Our ref: HA/2020/122770/01-L01
Your ref: BN/142/20/OUT
Date: 15 December 2020

OUTLINE PLANNING APPLICATION WITH ALL MATTERS RESERVED, OTHER THAN PRINCIPAL MEANS OF ACCESS, FOR UP TO 200 NO. DWELLINGS, WITH ACCESS TAKEN FROM MARSHALL CLOSE, ASSOCIATED INFRASTRUCTURE & LANDSCAPING & DEMOLITION OF EXISTING BUILDINGS. THIS APPLICATION IS A DEPARTURE FROM THE DEVELOPMENT PLAN, MAY AFFECT THE SETTING OF LISTED BUILDINGS, MAY AFFECT THE CHURCH LANE, BARNHAM CONSERVATION AREA & AFFECTS A PUBLIC RIGHT OF WAY LAND SOUTH OF BARNHAM STATION BARNHAM

In the absence of an acceptable flood risk assessment (FRA) we object to this application and recommend that planning permission is refused.

- Site_Boundary
- 1% AEP + 35% (Defended Fluvial)
- 1% AEP + 45% (Defended Fluvial)
- 1% AEP + 105% (Defended Fluvial)

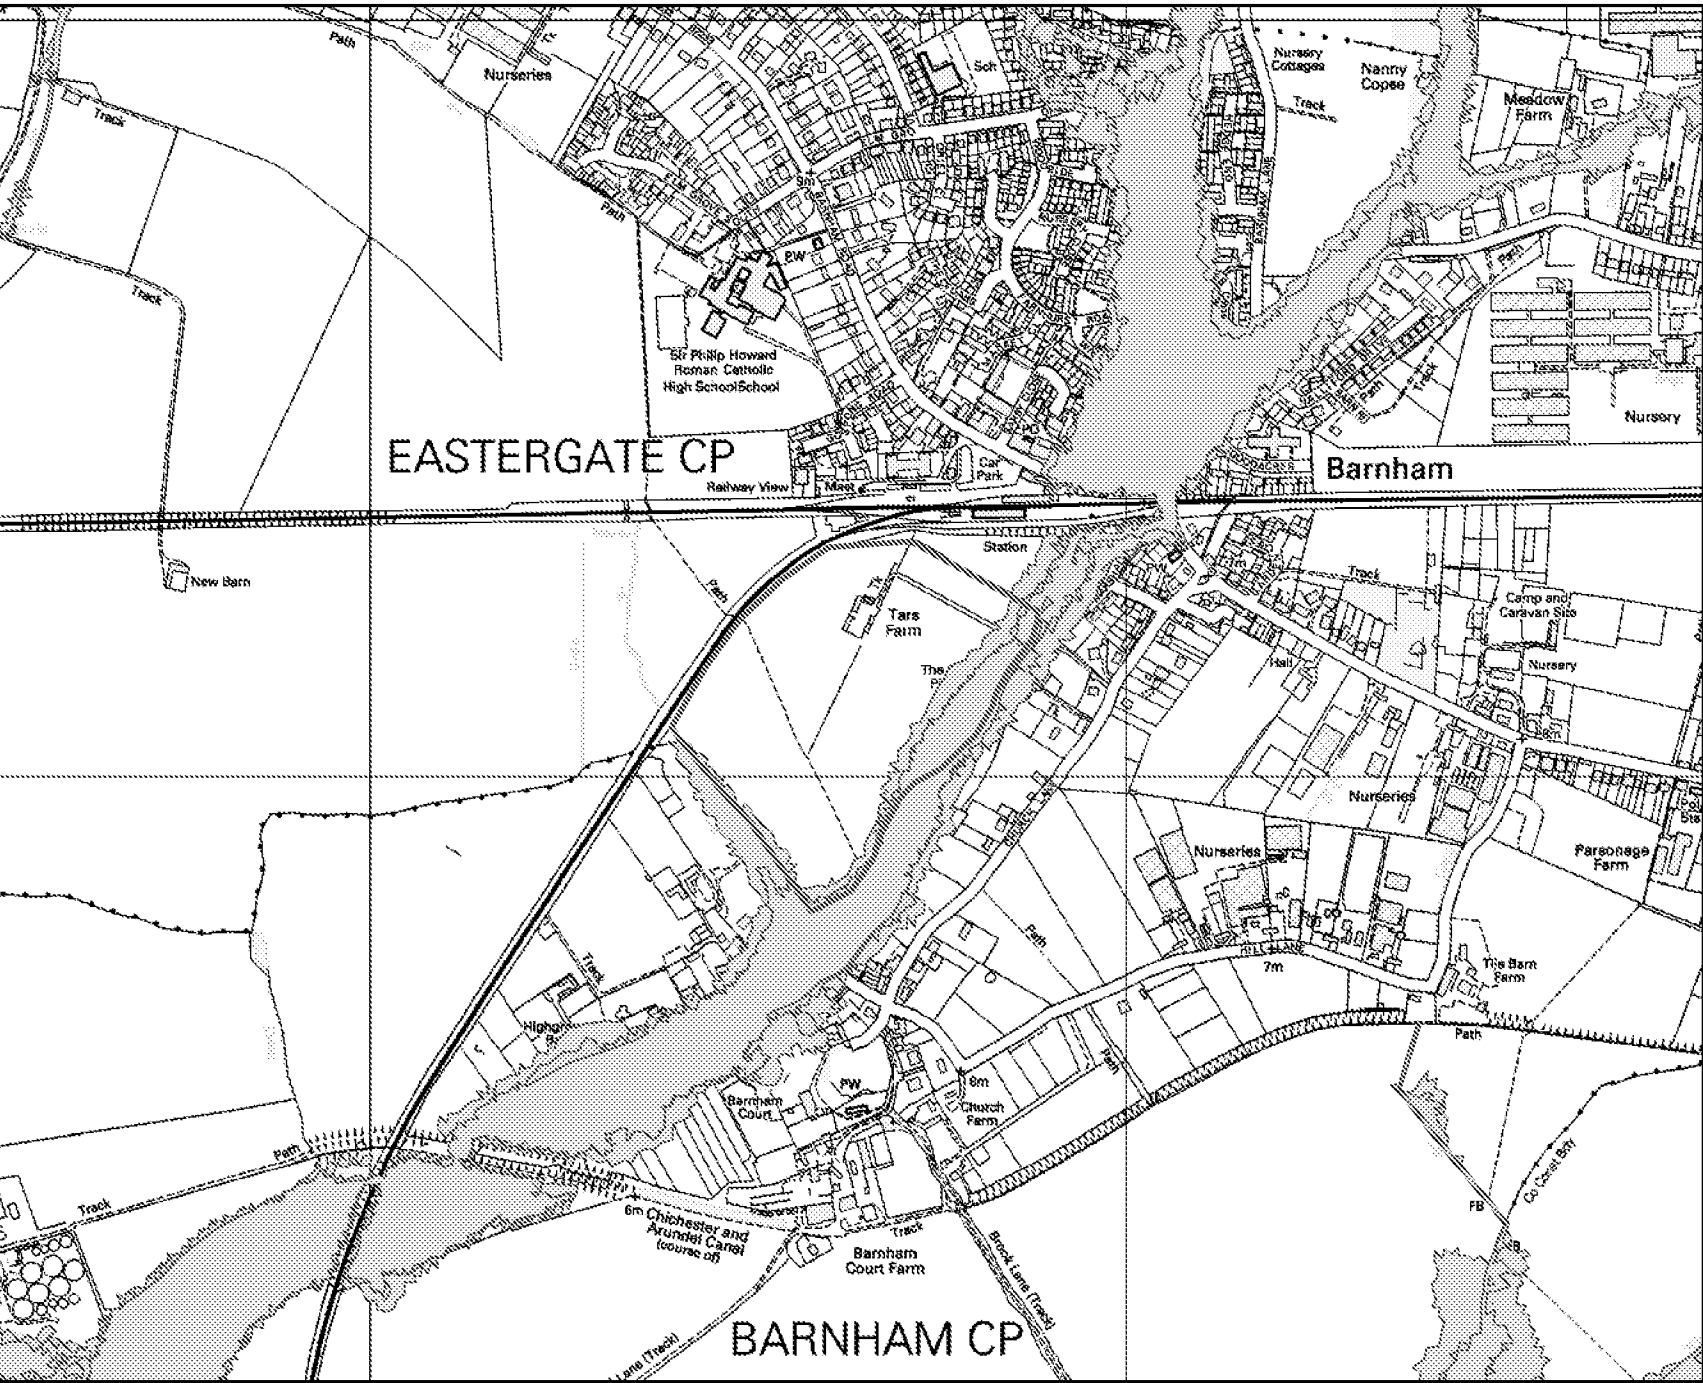
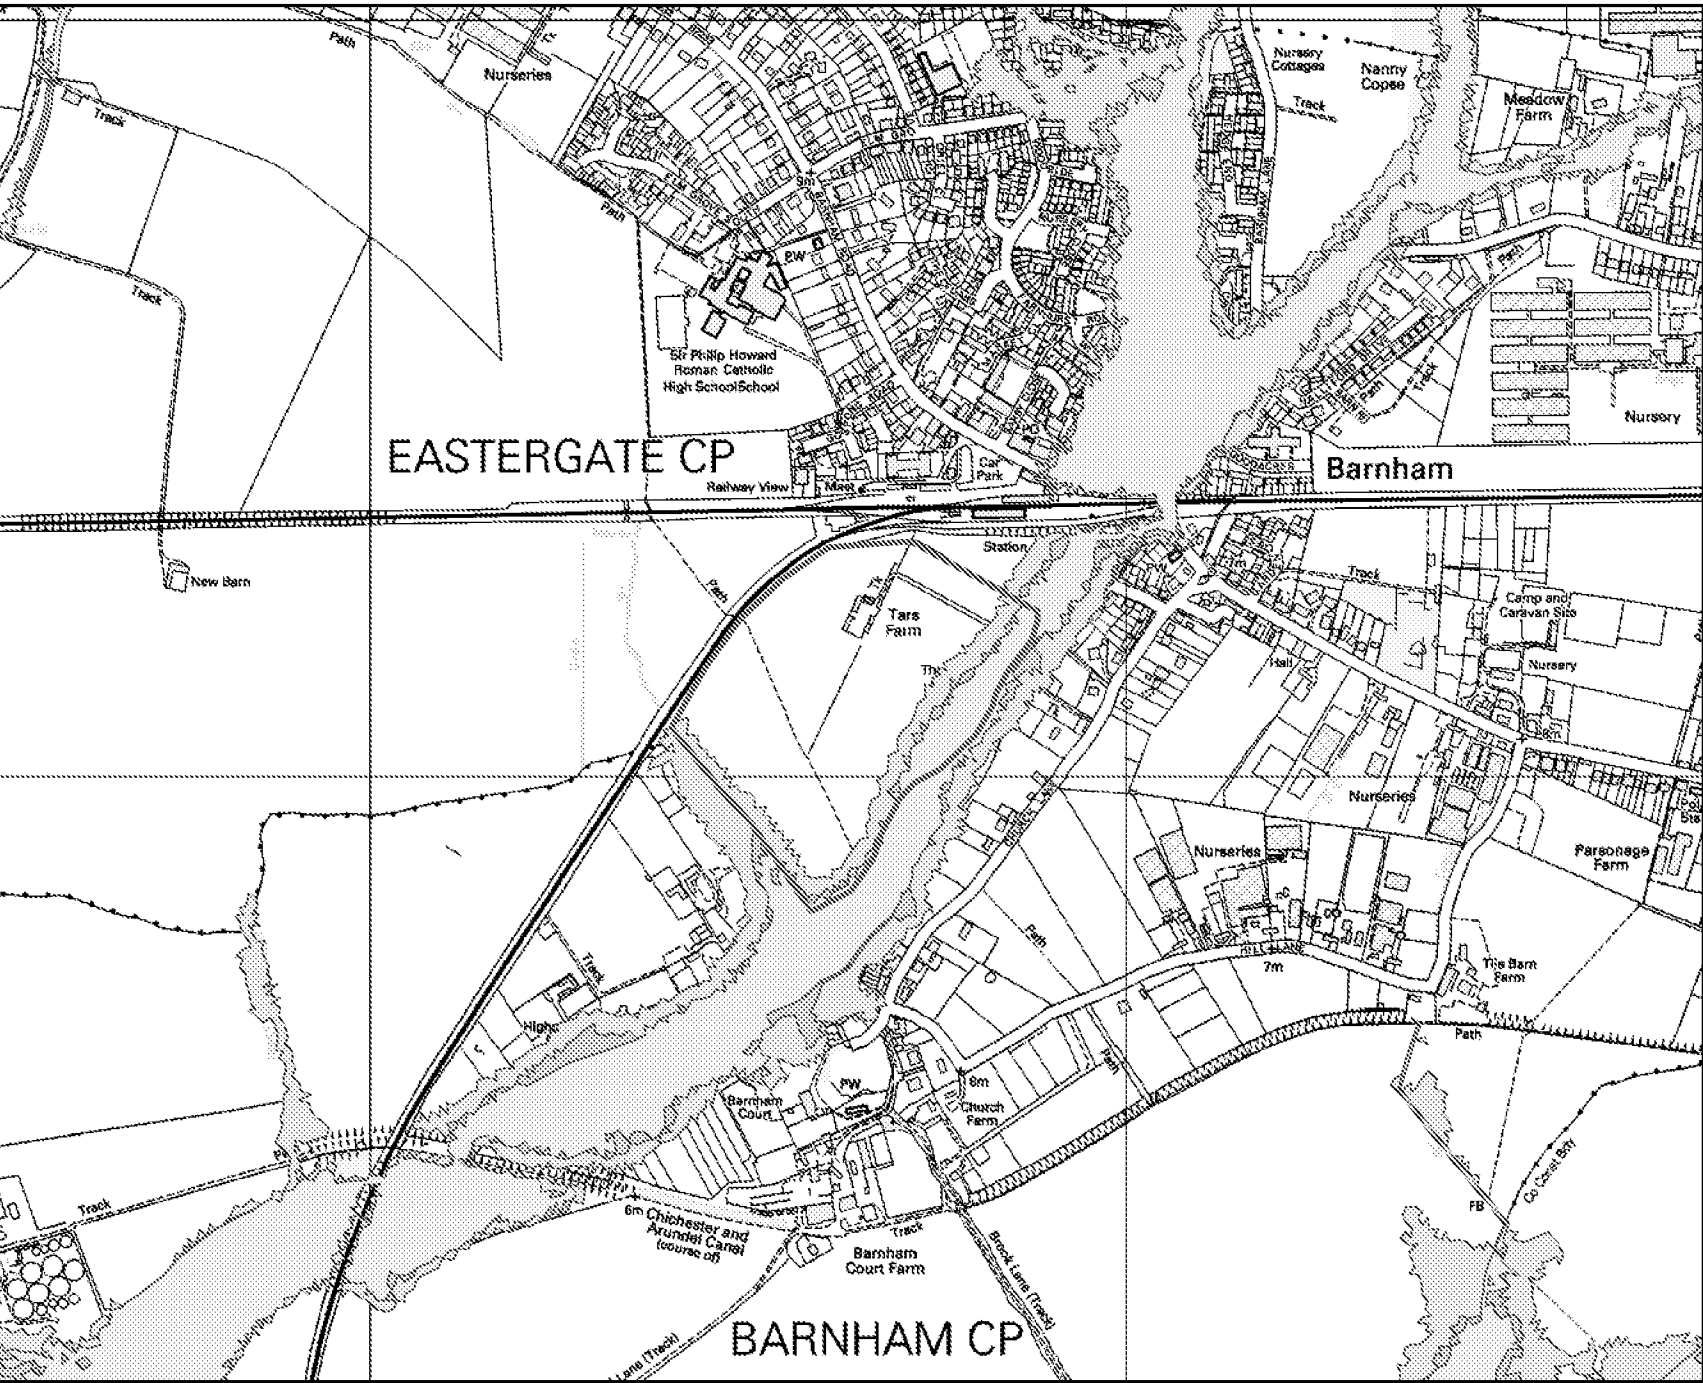
There is no assessment of the impact of climate change using the appropriate climate change allowances according to our guidance 'Flood risk assessments: climate change allowances'. The EA product 4 data in Appendix 4 provided outlines, levels and depths for the climate change events (1% AEP plus 35%, 45% and 105% increase in flow). The FRA states that the dwellings will be located in Flood Zone 1 (low risk). However, it is not clear if they will all be located outside the climate change extents, and if not adequate mitigation measures should be provided (e.g. finished floor levels should be at least 300mm higher than the climate change levels).

To overcome our objection, the applicant should submit a revised FRA which addresses the points highlighted above.
